## **Application by Longfield Solar Energy Farm Limited for an Order Granting Development Consent for the Longfield Solar Farm project.**

### **The Examining Authority's Written Questions and Requests for Information (ExQ1)**

**Issued on 26 July 2022**

TITLE: Works Plan Sheet Overview

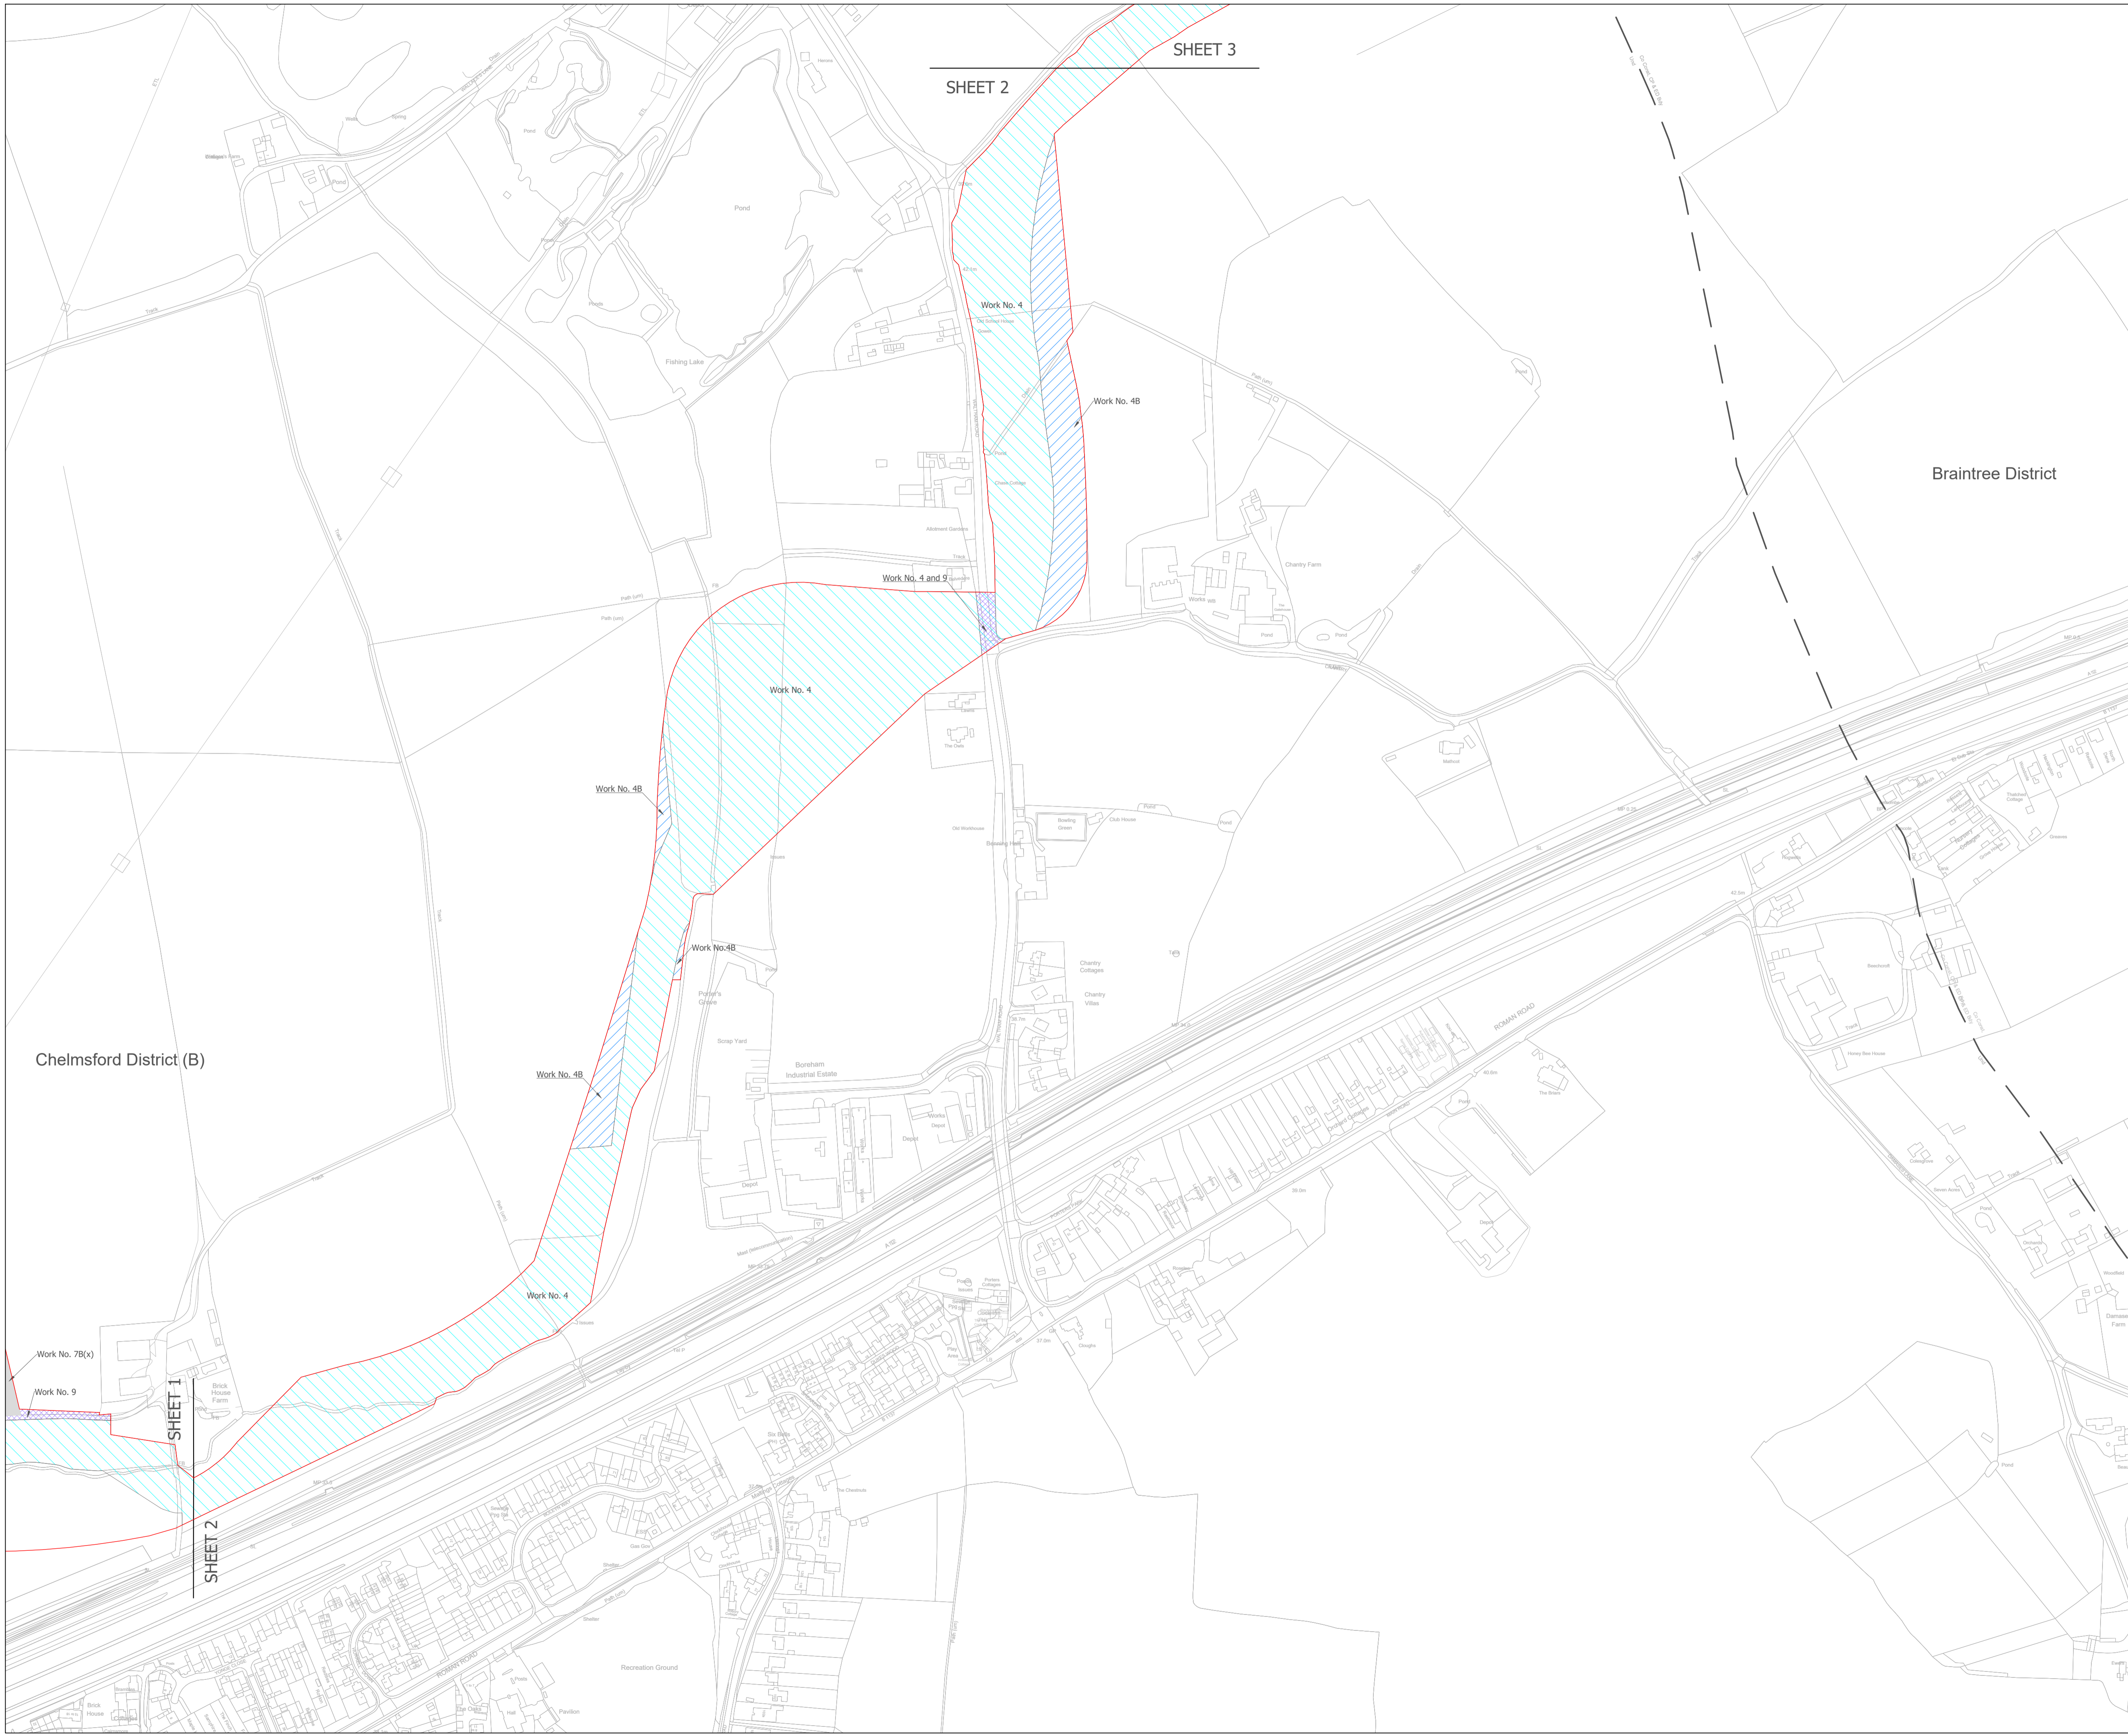
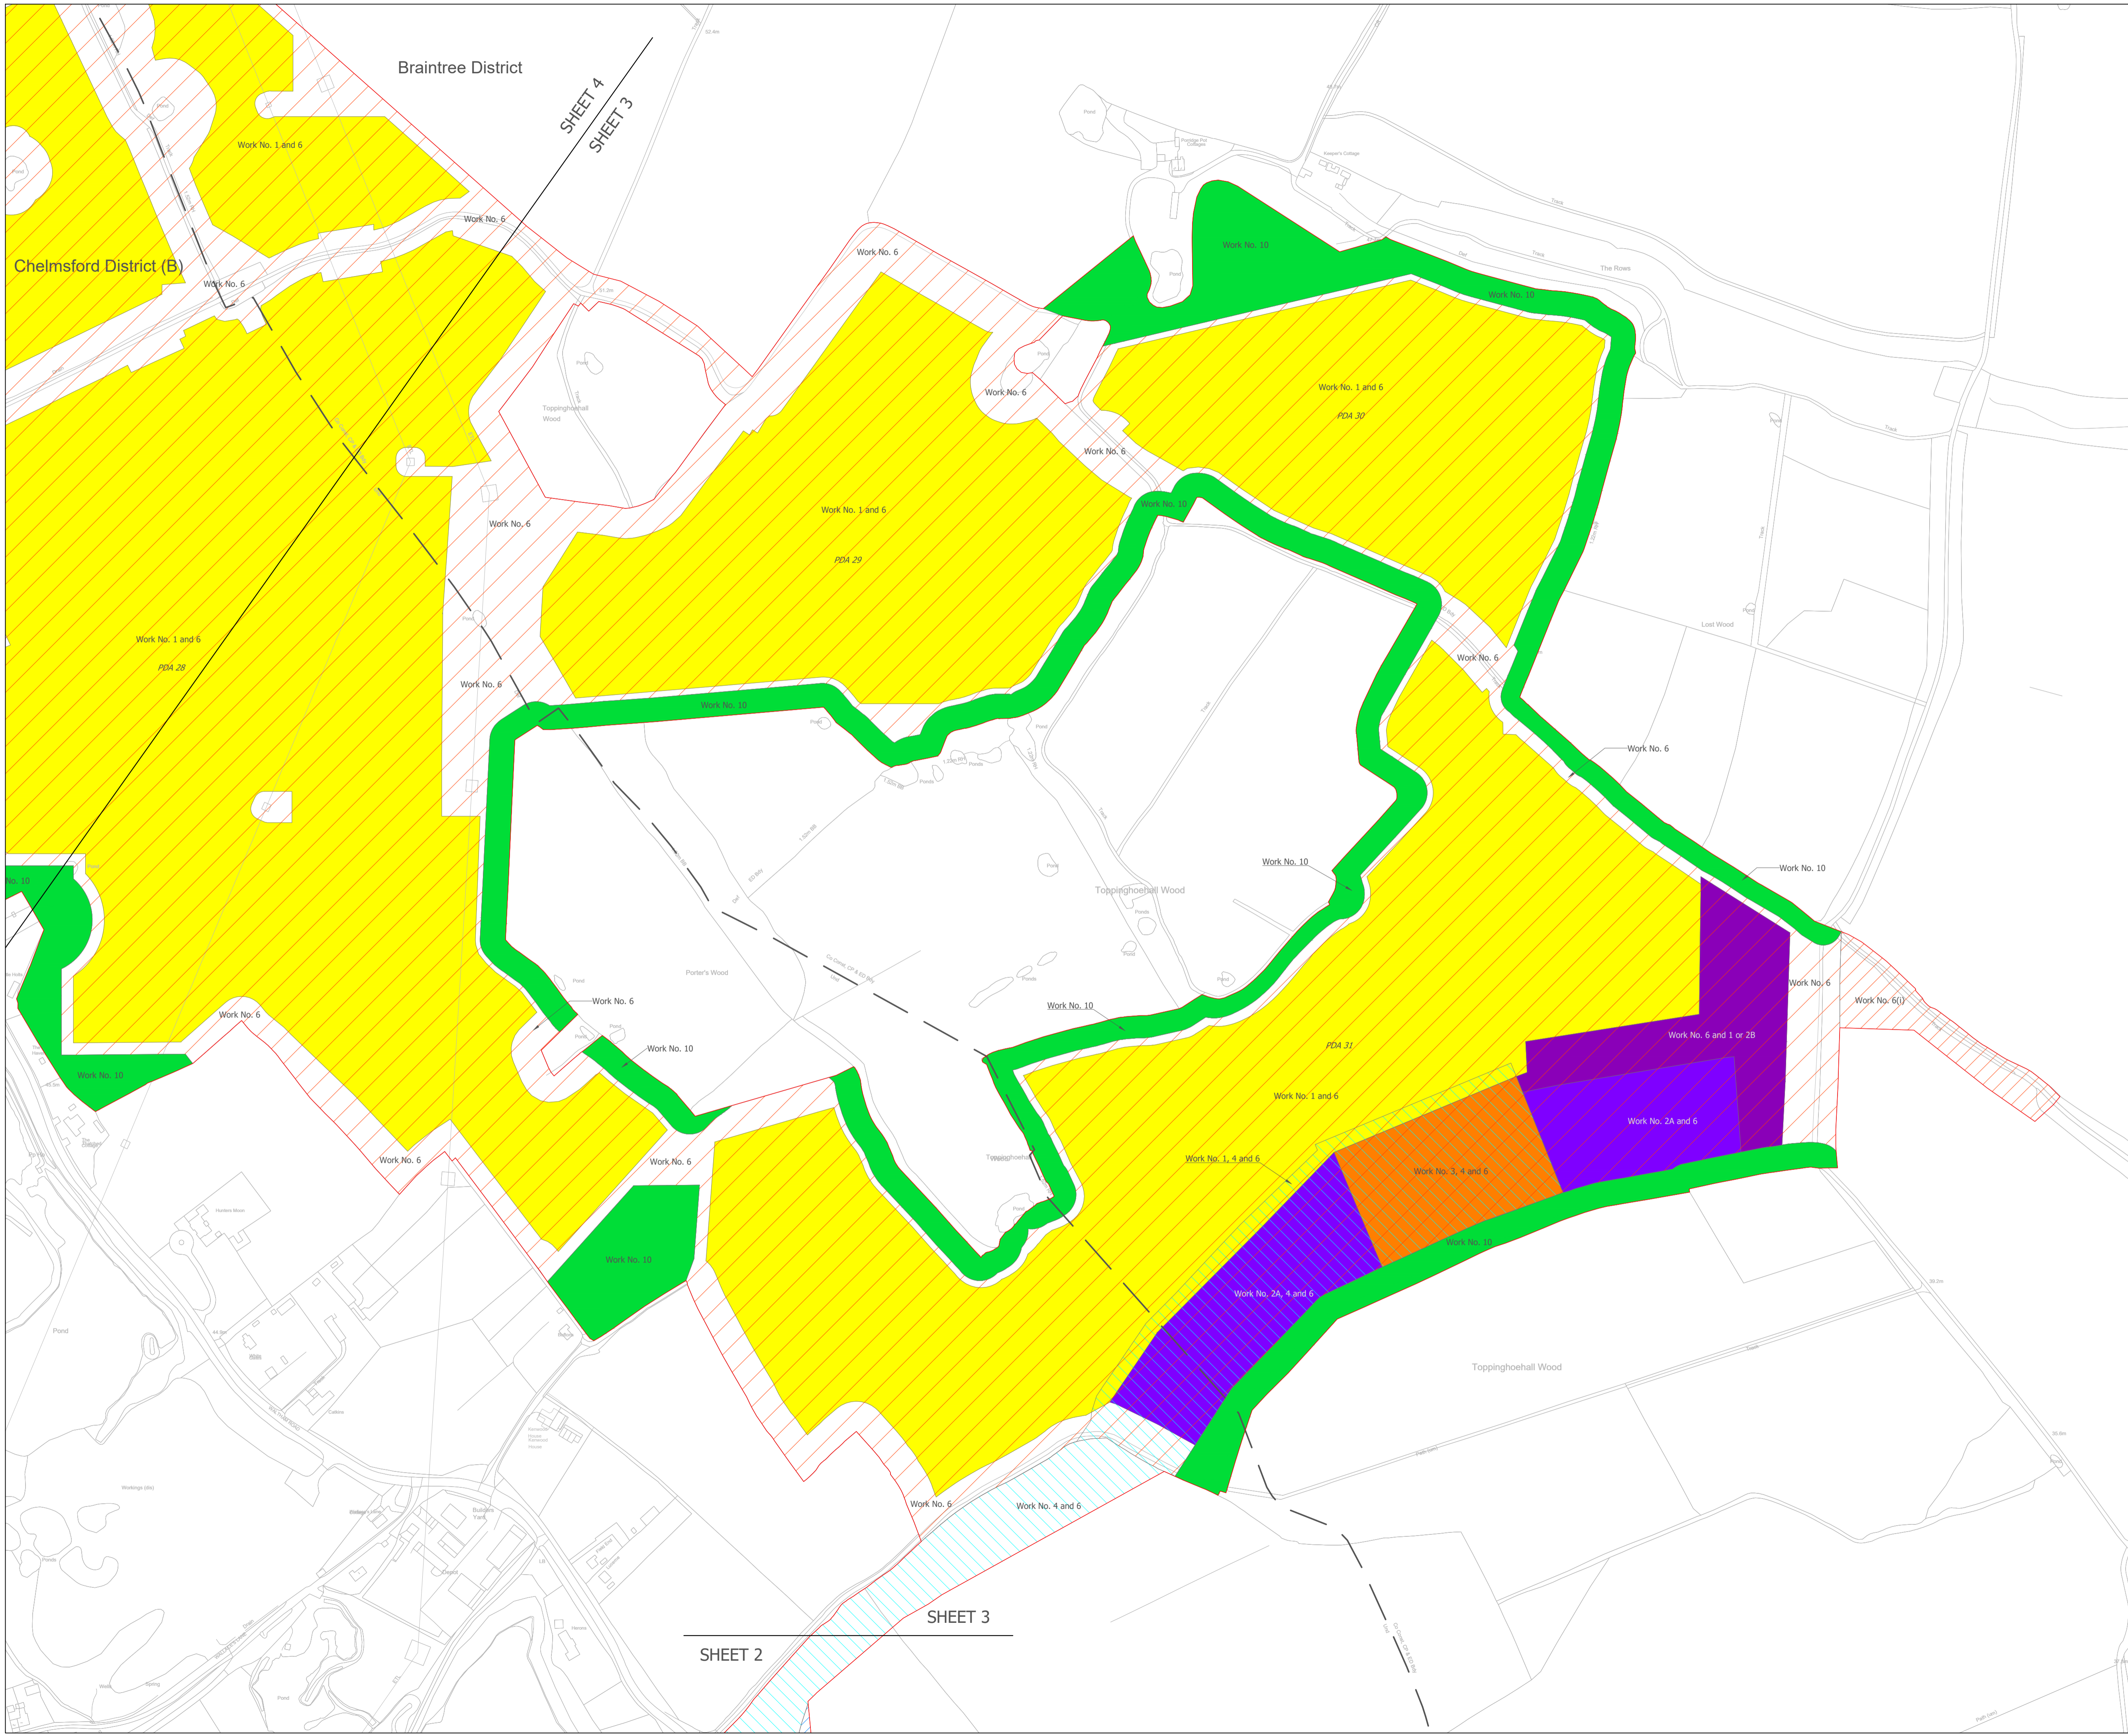
1.3.2	Applicant	The works plans show wide limits of deviation for a number of the works proposed. Please explain why this degree of flexibility is required and confirm that the limits of deviation have been reduced to the minimum extent necessary.
